Bowmans Creek Wind Farm (SSD-10315)
Request for additional information

I refer to the assessment of the Bowmans Creek Wind Farm (SSD-10315). The Department is requesting that you provide additional information on the matters outlined below.

**FIGURE 9**

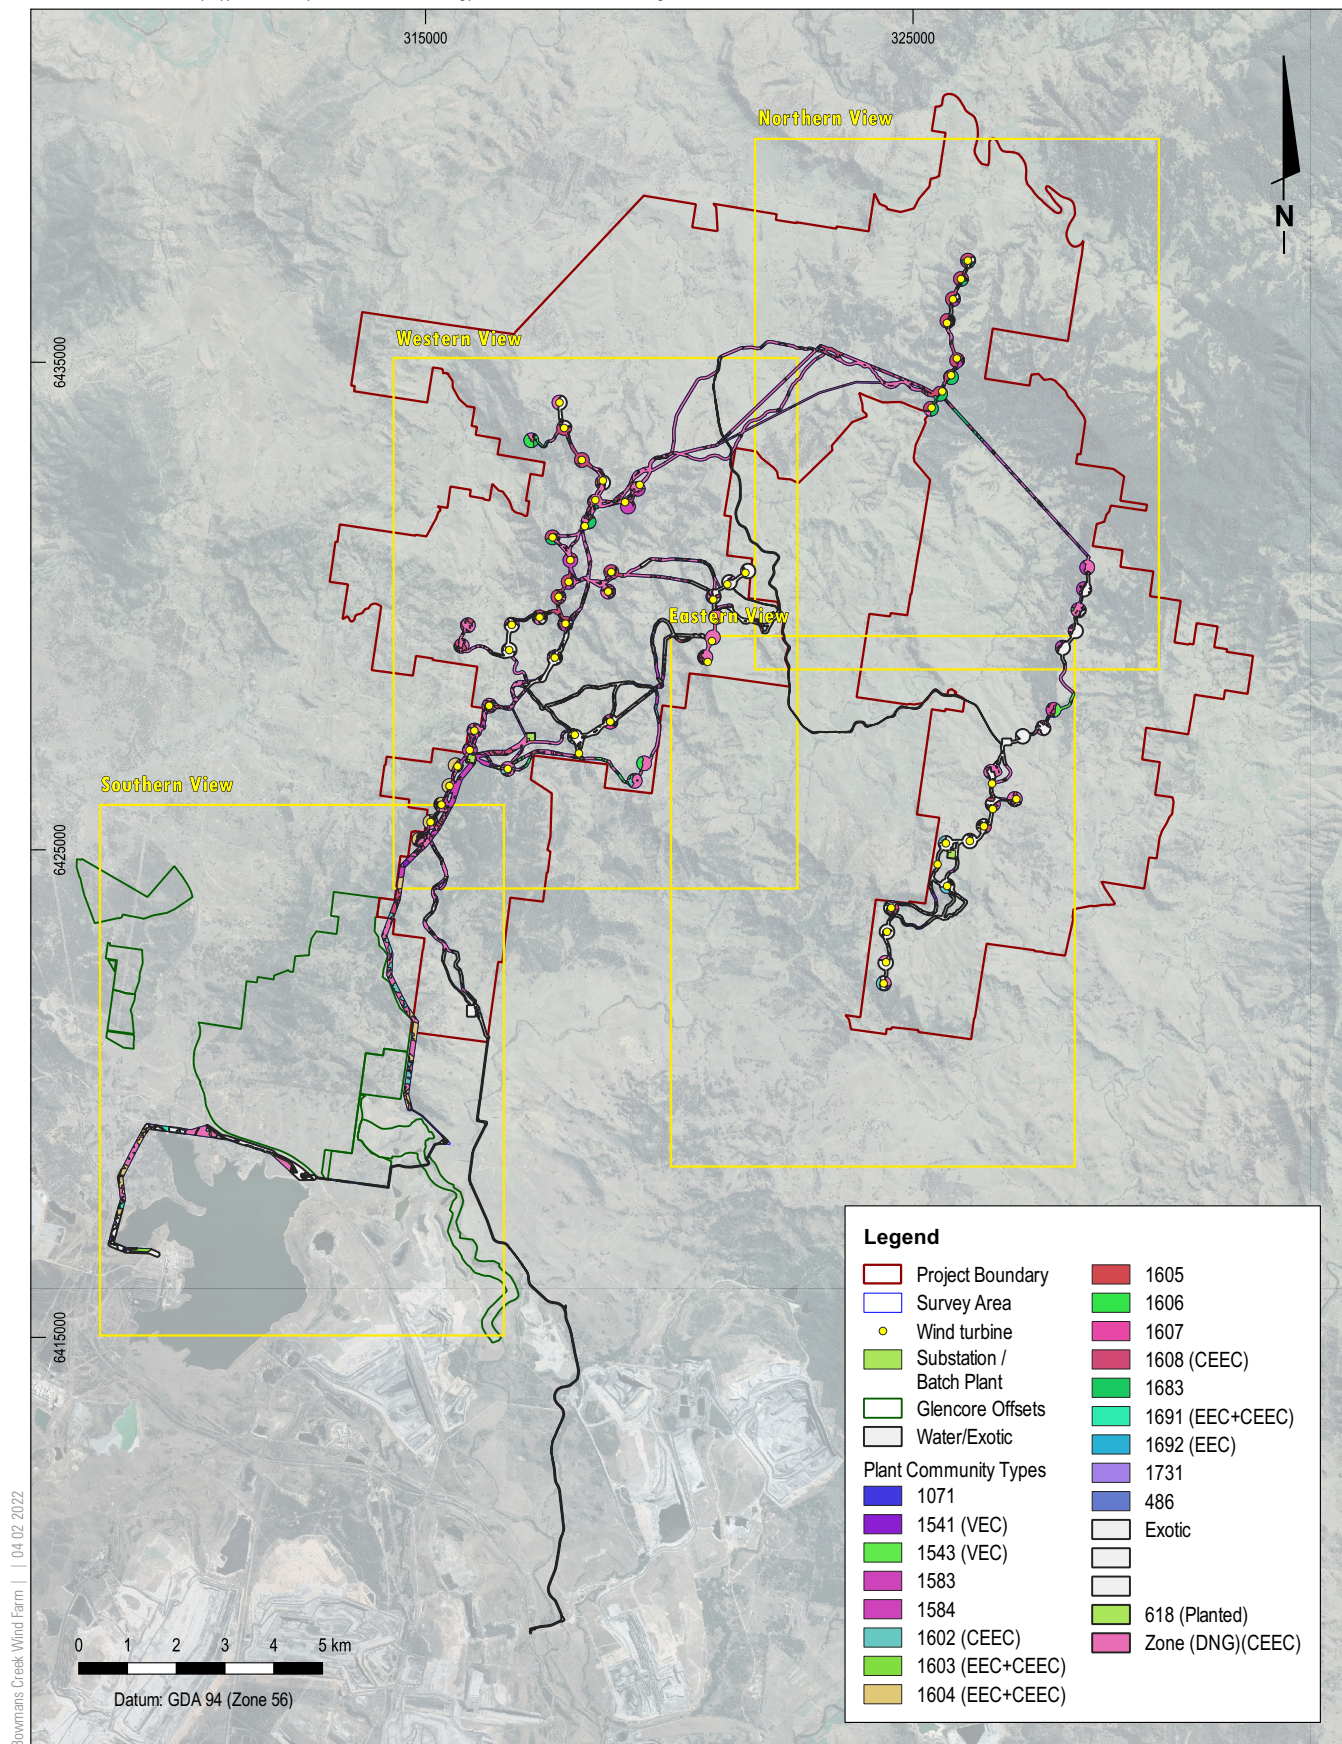
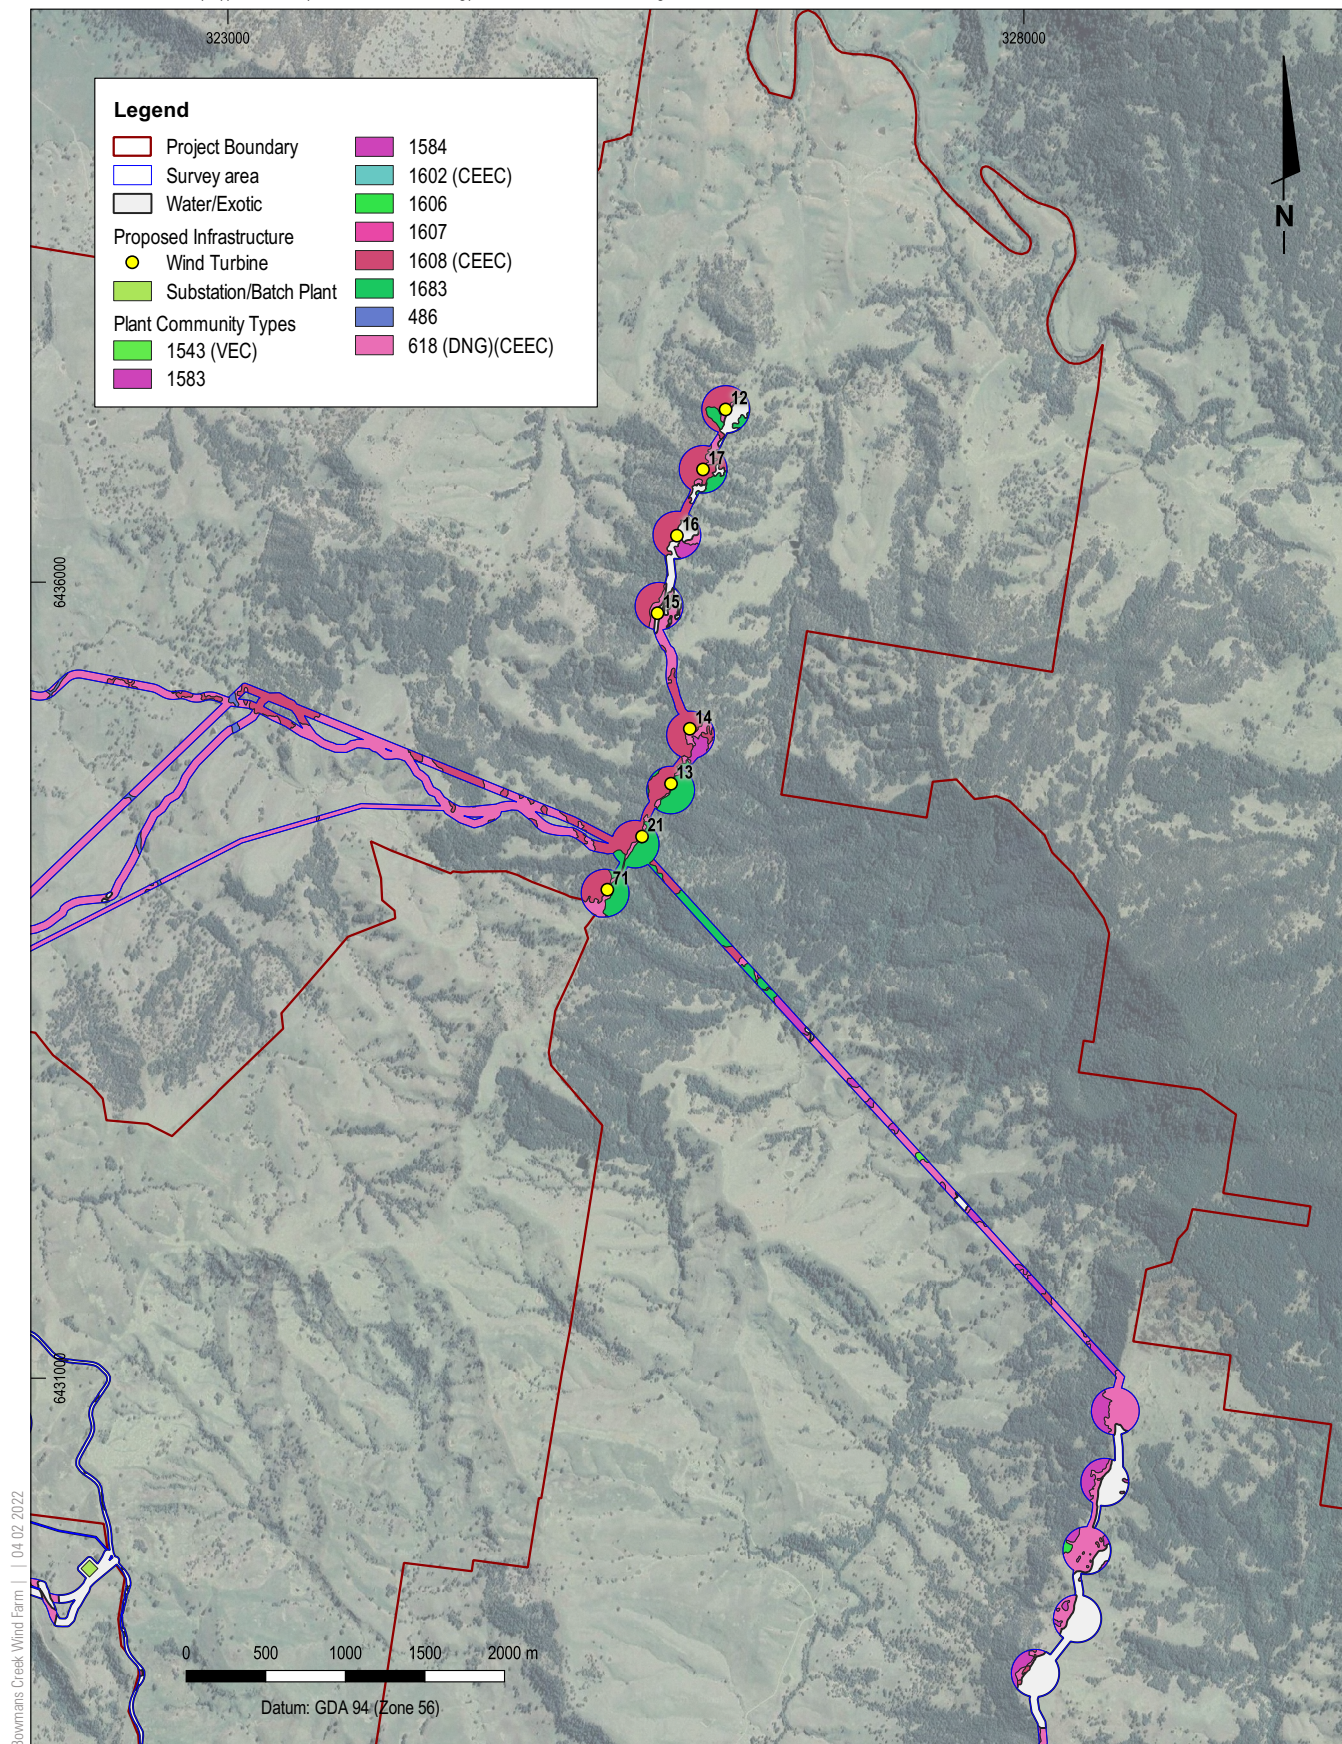
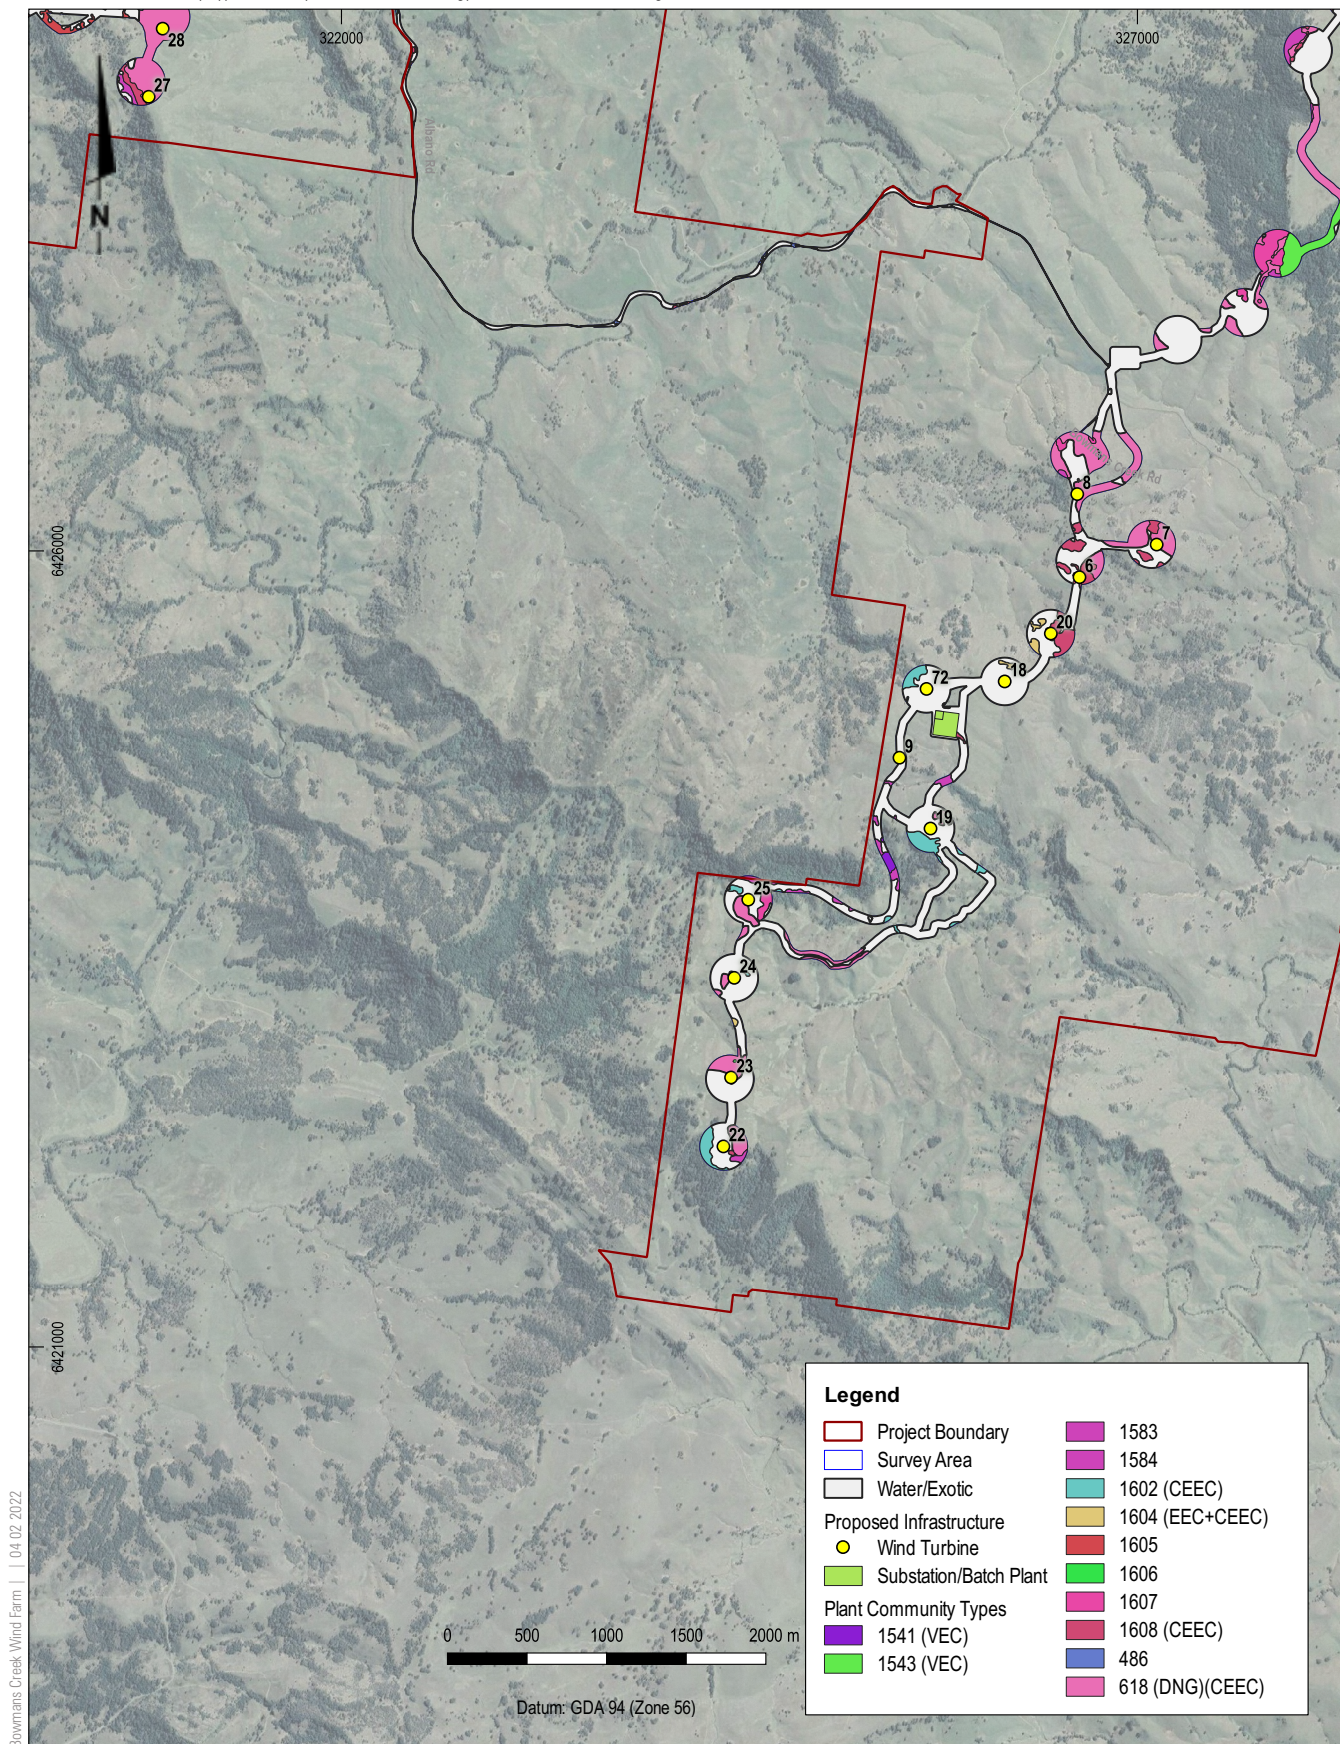
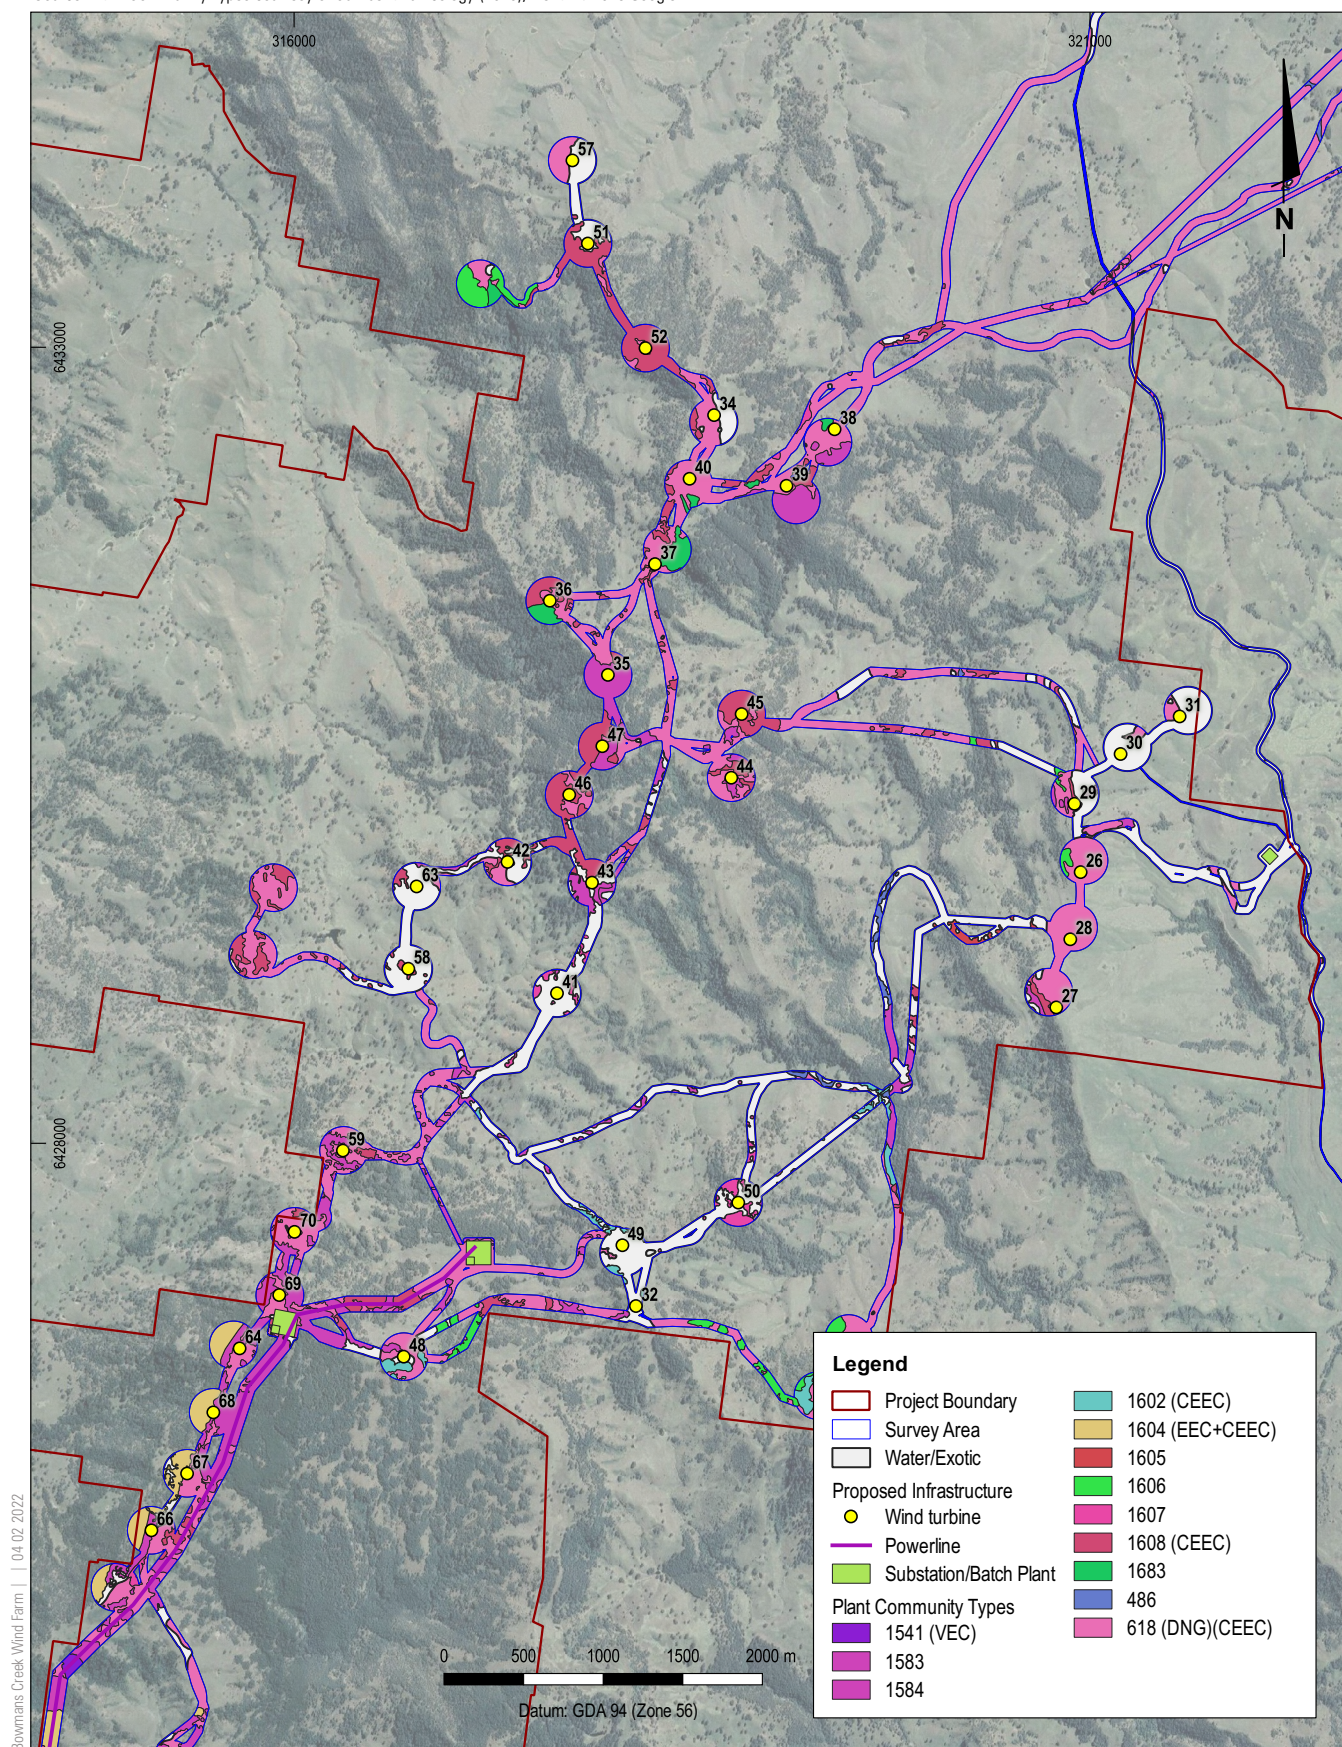
- Provide an updated version of figures 9 to 13 of the Amendment Report that shows the amended development footprint – identify turbines and key infrastructure;
- Once the schedule of road upgrades is finalised, confirm that all disturbance associated with road upgrades has been assessed; and
- Confirm which threatened flora and fauna species would be the subject of targeted surveys.
